# LEE WHARF

**RE: Proposed Amendment to Major Projects No. 05-0007**  
**Property: Lee Wharf C Building, 9 Honeysuckle Drive, Newcastle**

This submission has been prepared to address the concerns of the Department of Planning regarding the use of the outdoor deck to Lee Wharf C Building the subject of Major Project No. 05-0007 and seeks to amend the consent to permit the use of the deck in accordance with Condition A6(1).

**PART FLOOR PLAN
AND ELEVATIONS**

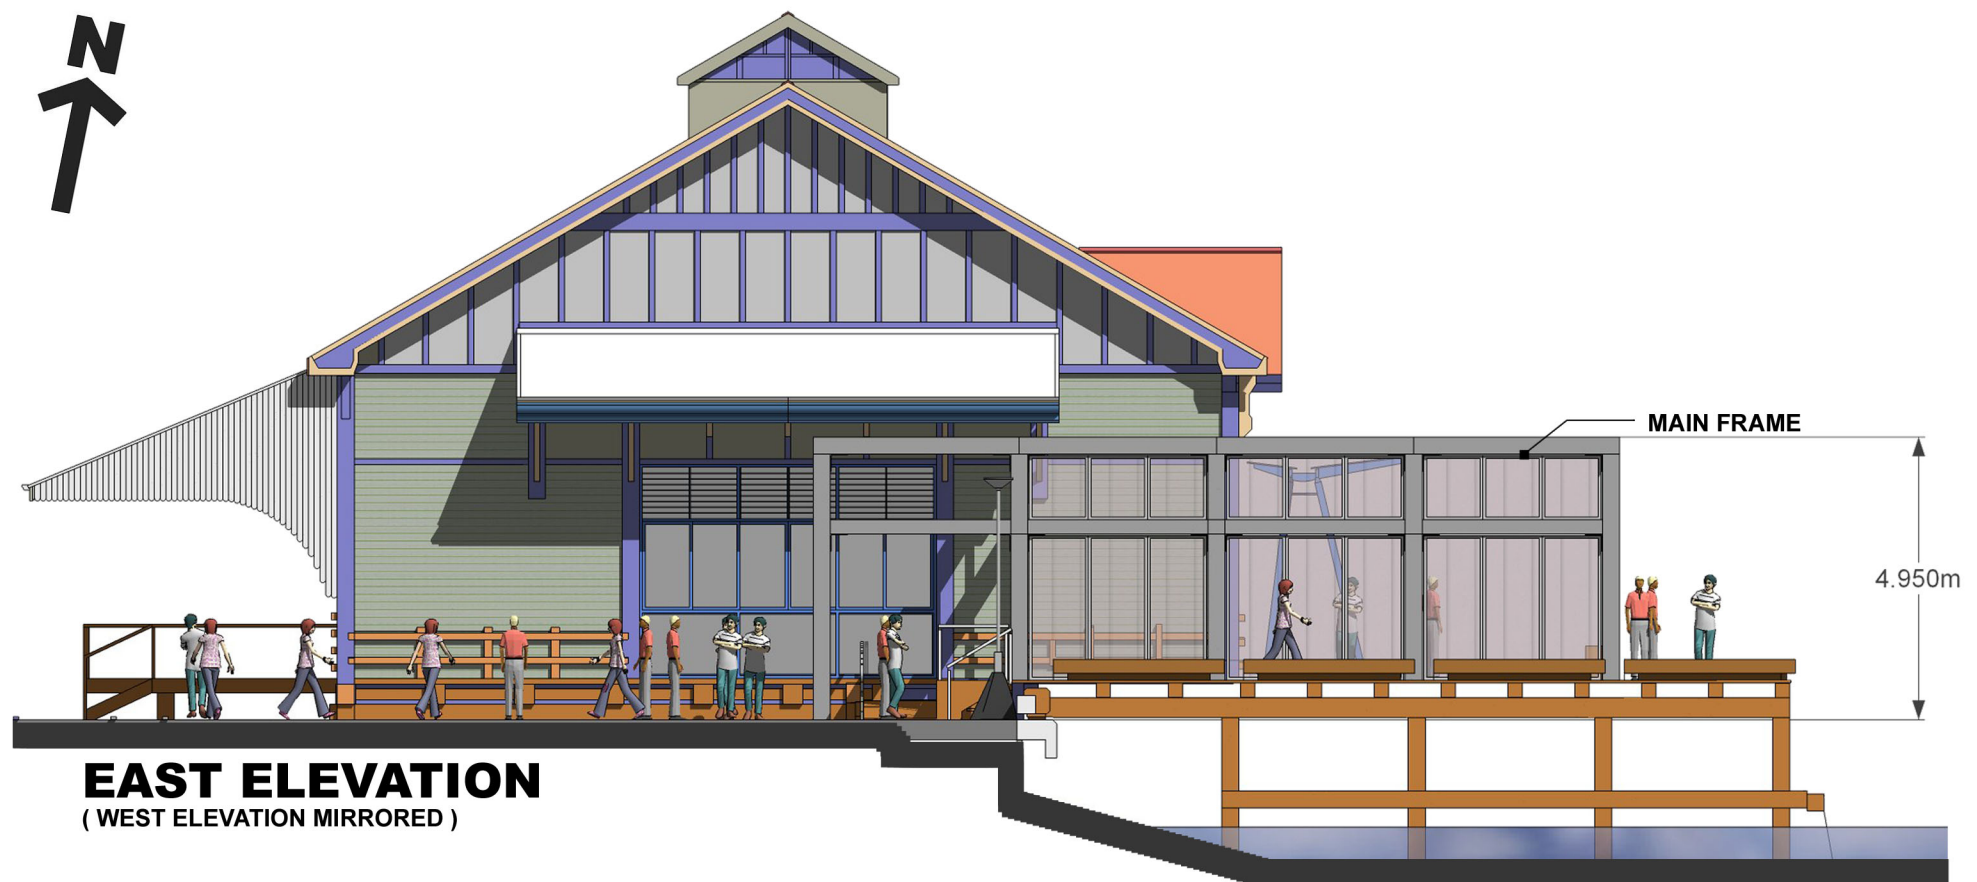
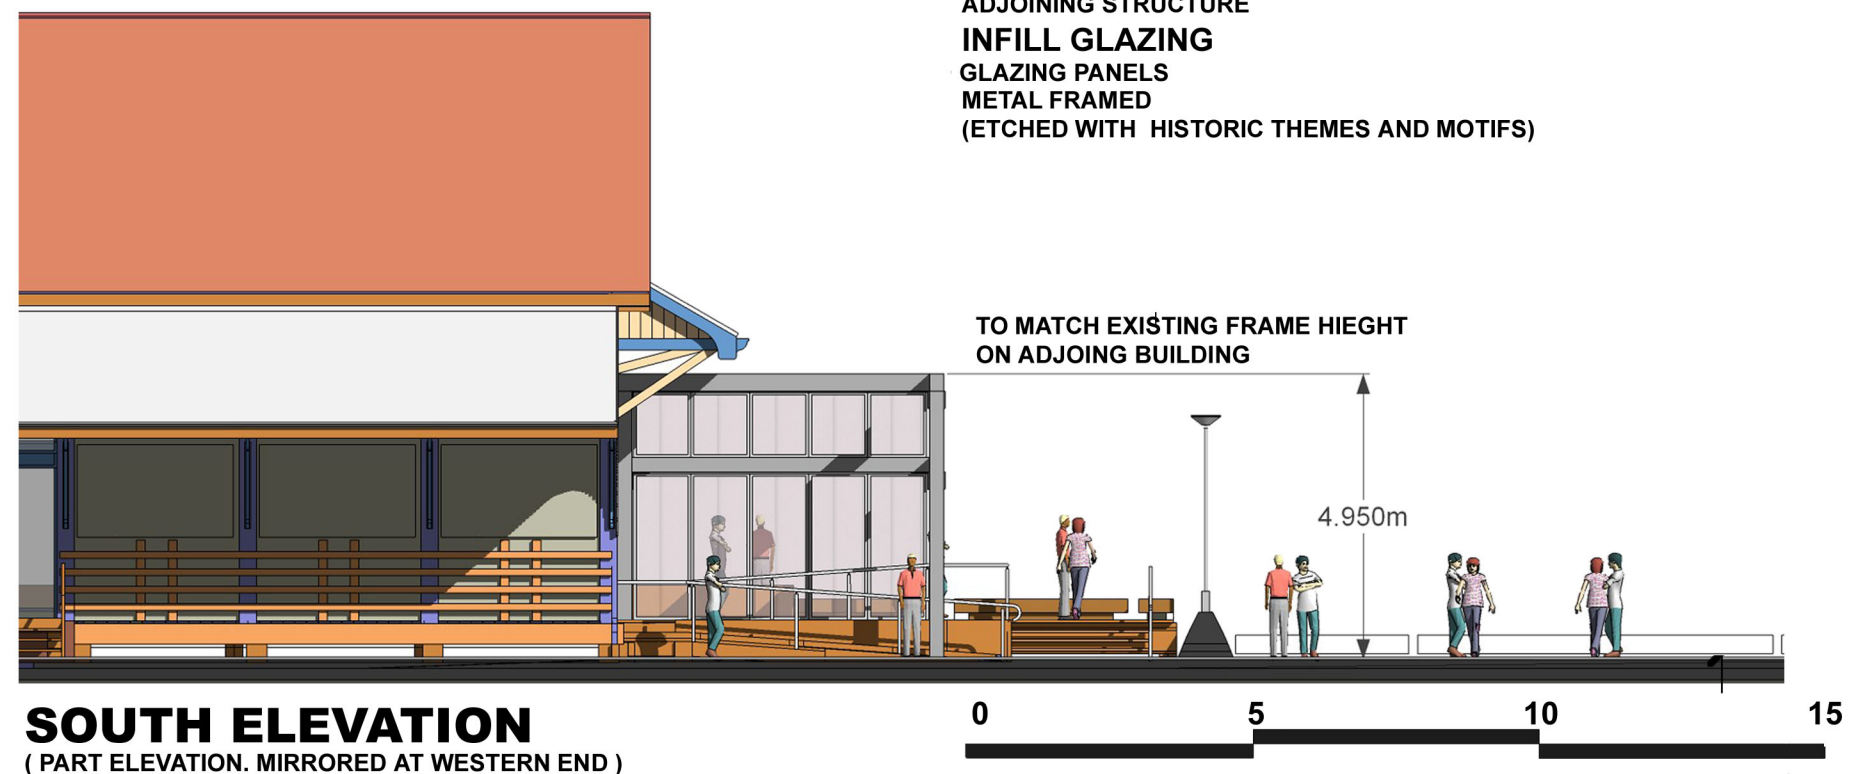
The 1.5m and 1.8m acoustic screen approved pursuant to Reverb Acoustics Noise Impact Assessment Report dated December 2007 is proposed to be modified to 4.27m from deck level (4.95m from ground level) as illustrated in the Architectural drawings prepared by EJE Architects dated 15 June 2009. The increase in height of the approved screen will attenuate noise from the use of the deck in the extended hours from 10.00PM to midnight.
